23 October 2012

Our ref: JS/12-197

re: SSD-4972, Four Points By Sheraton Hotel Expansion

JUN 21 9AM

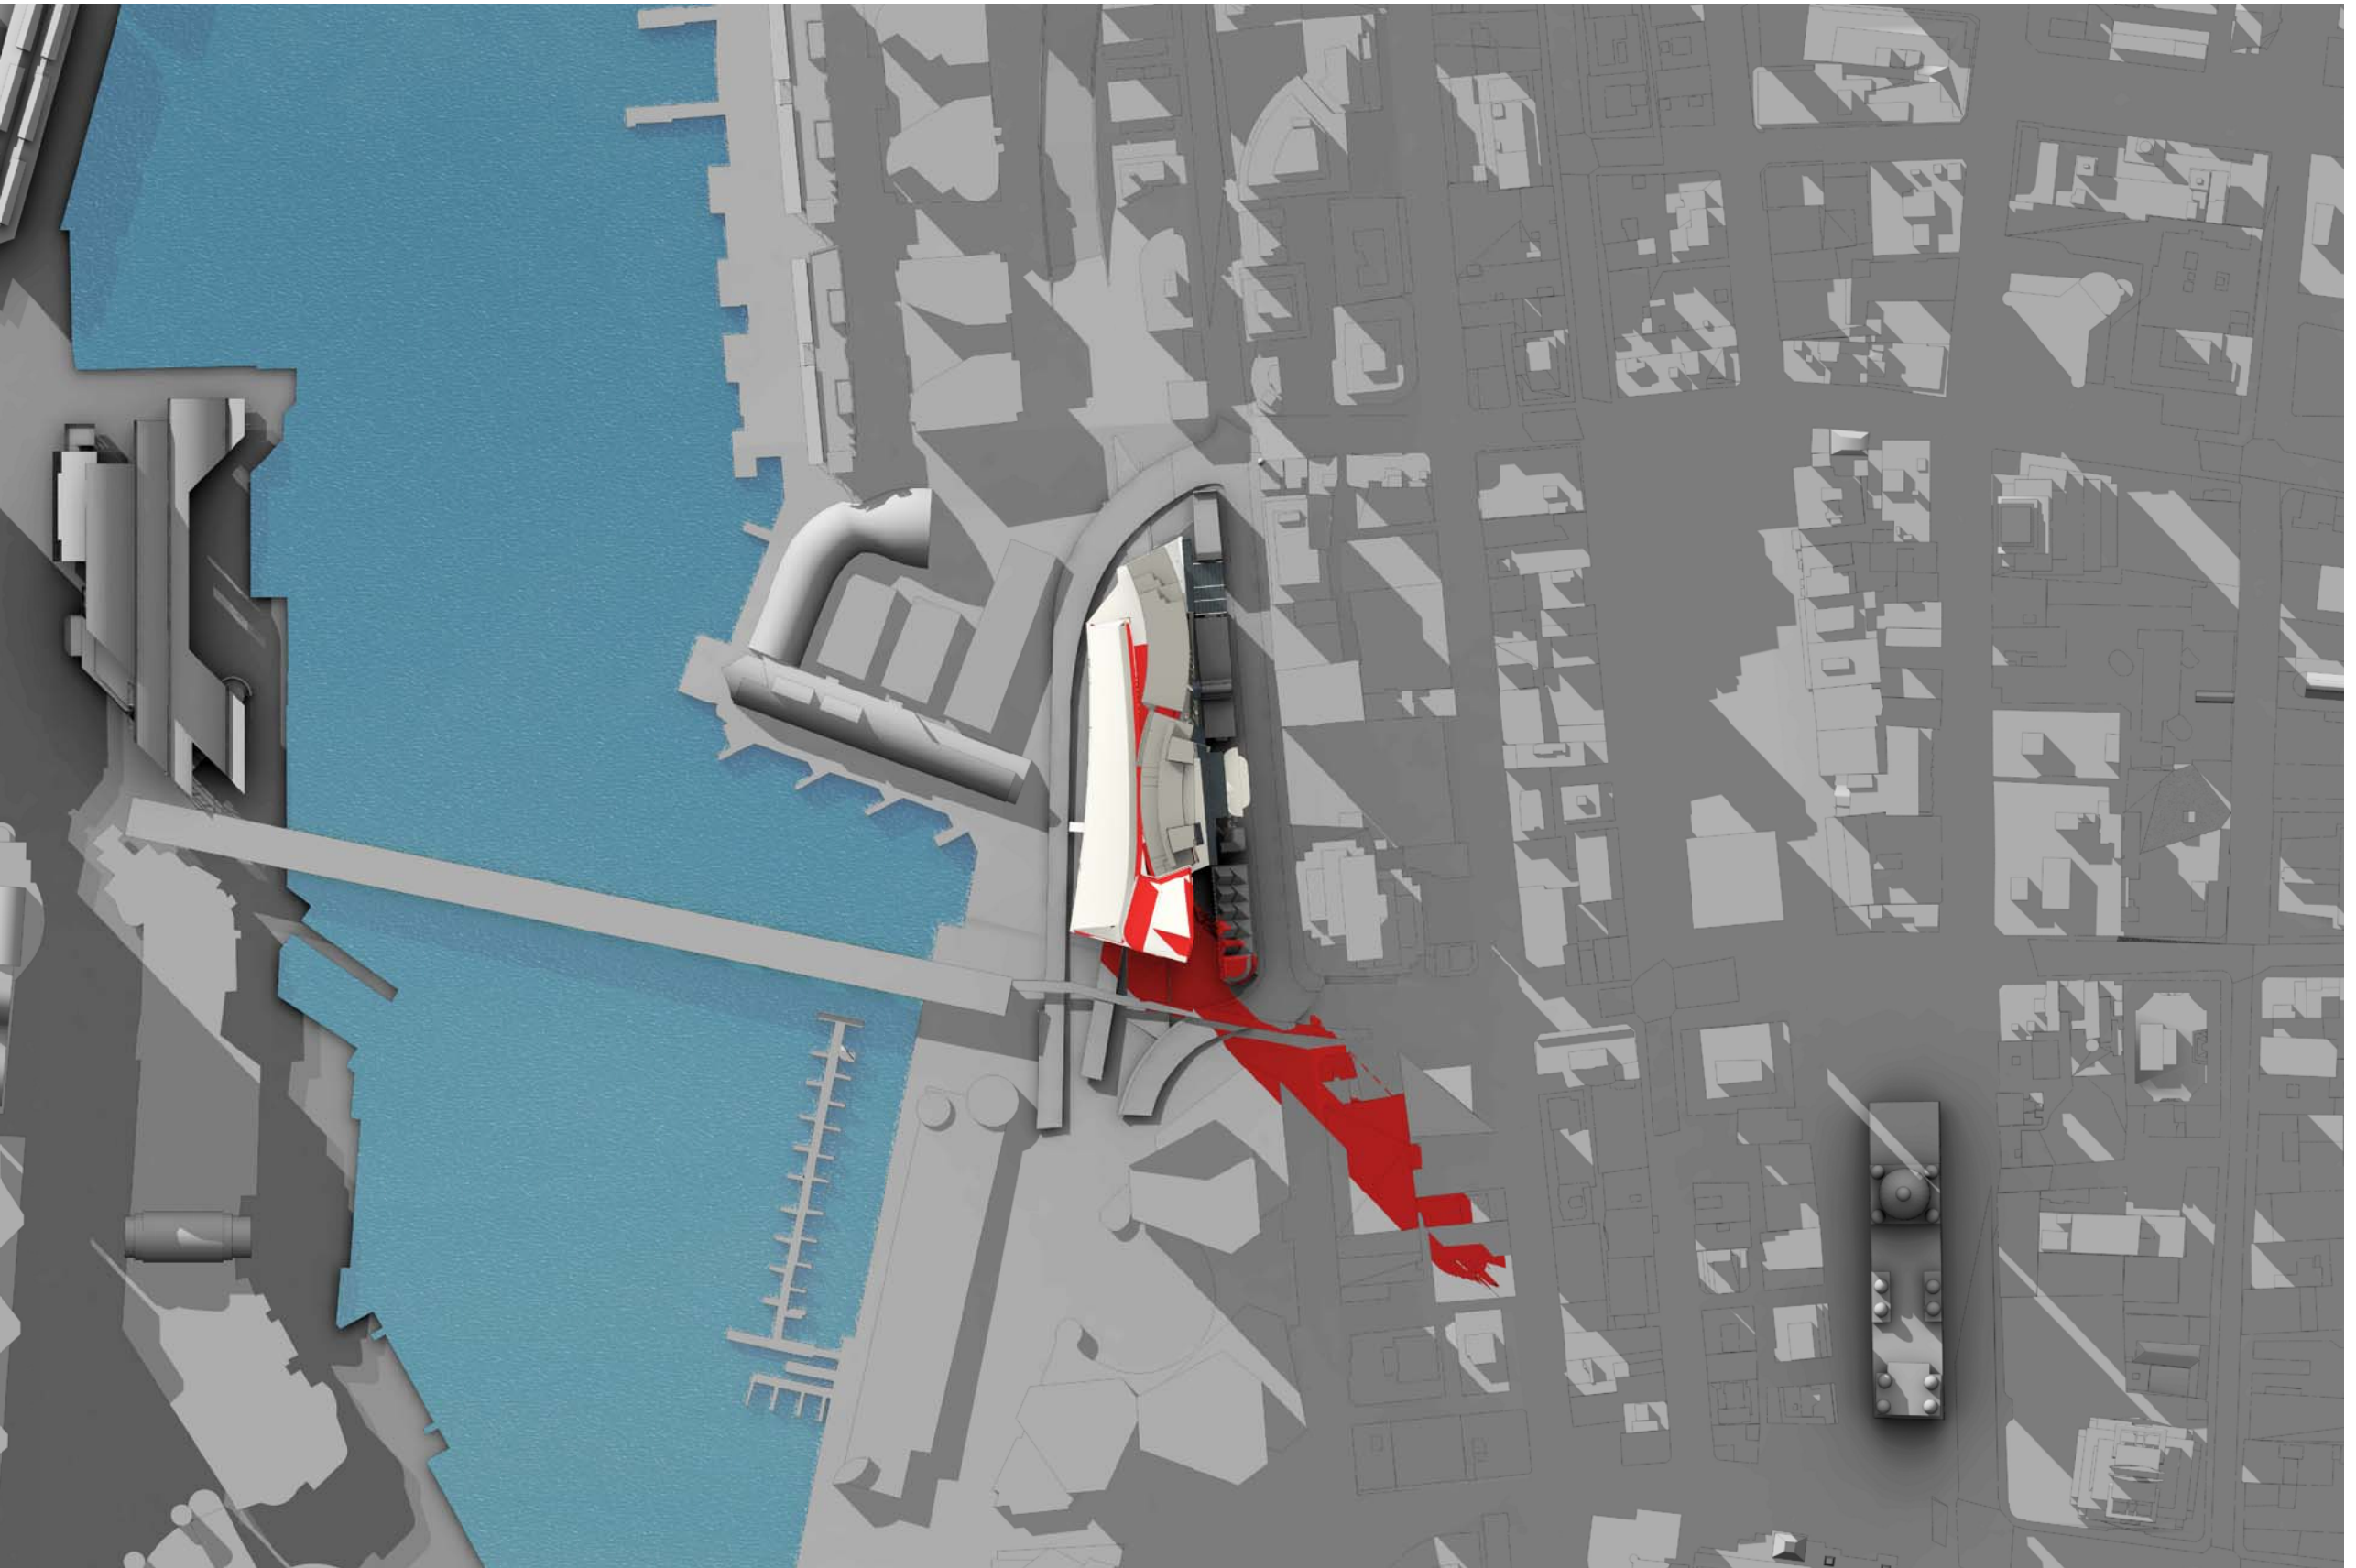
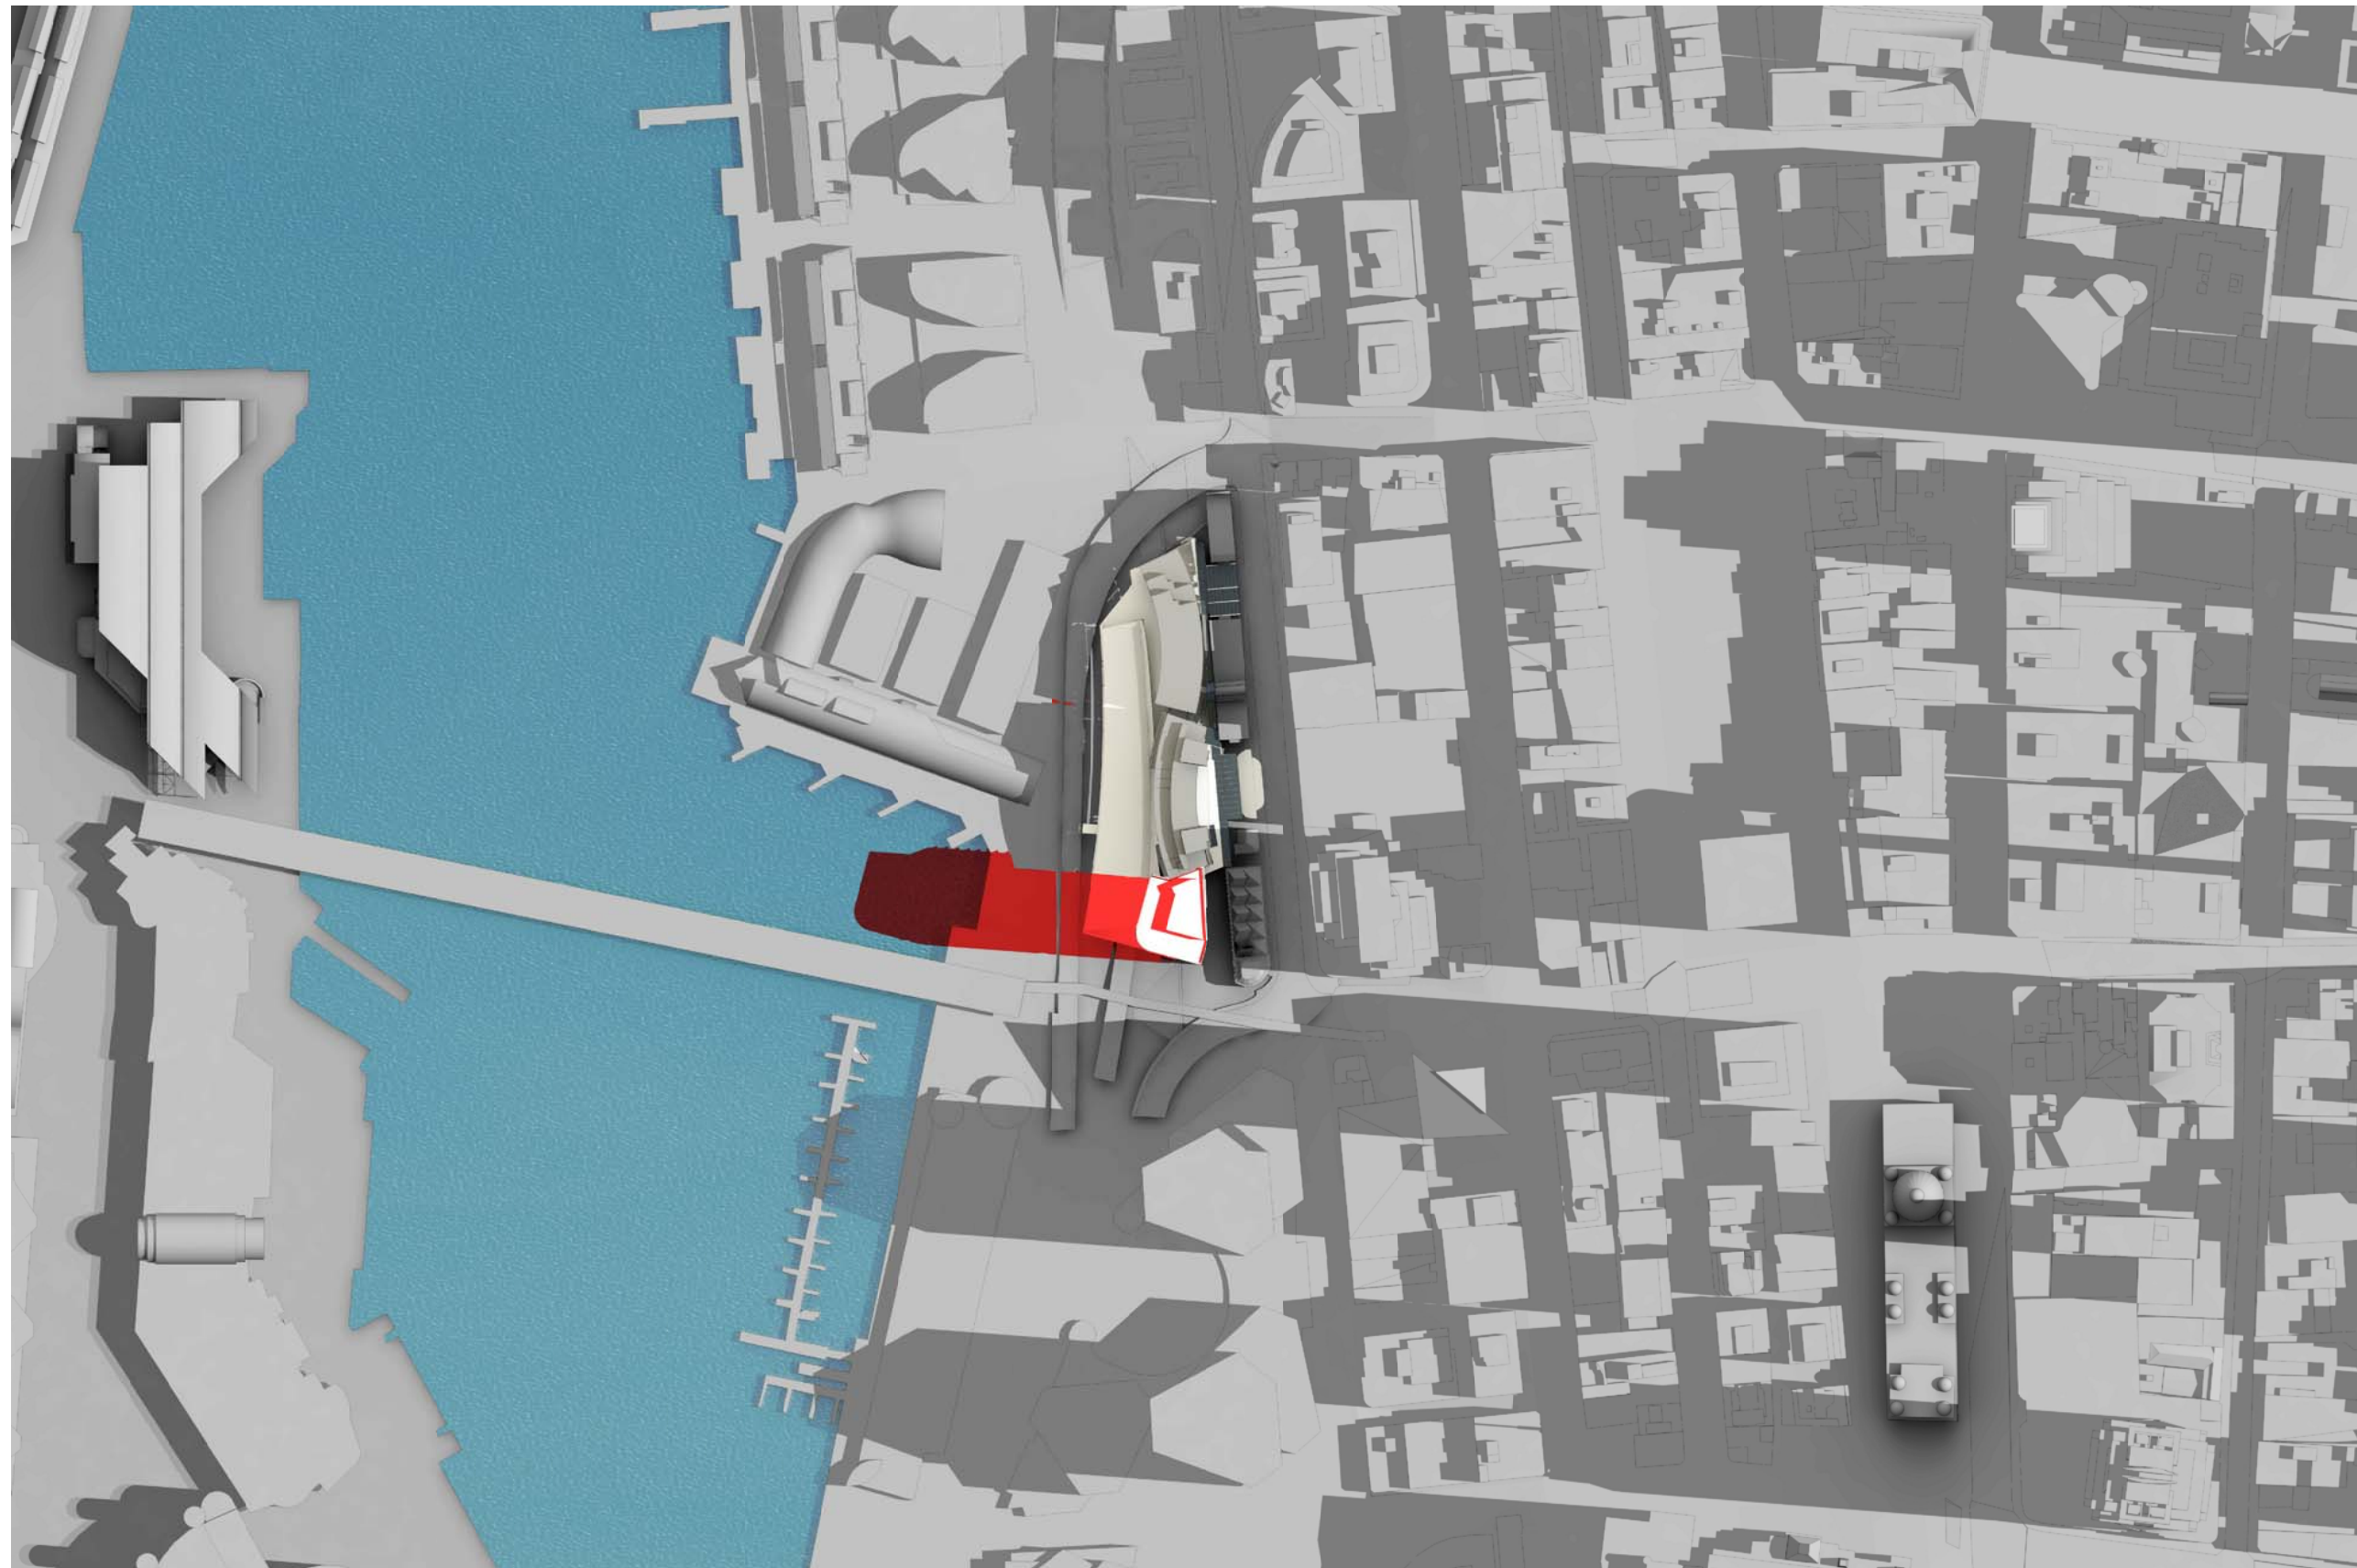
- The shadow diagrams placed on public exhibition with the State Significant Development Application are unclear. Our client should be provided with shadow diagrams, prepared on an hourly basis on June 21 (between 9am and 3pm) in both plan and elevation form to detail the overshadowing impacts from the proposed development on the forecourt (in front of the CBA tower) and on the CBA Tower itself;
- Location of cranes, Noise, Vibration and Air Quality – the proponent has stated that they will prepare a construction management plan. Our client would like to have some input into this plan – prior to the approval being implemented; and
- Traffic and Parking – the proponent has stated that they will prepare a construction traffic management plan. Our client would like to have some input into this plan – prior to the approval being implemented.
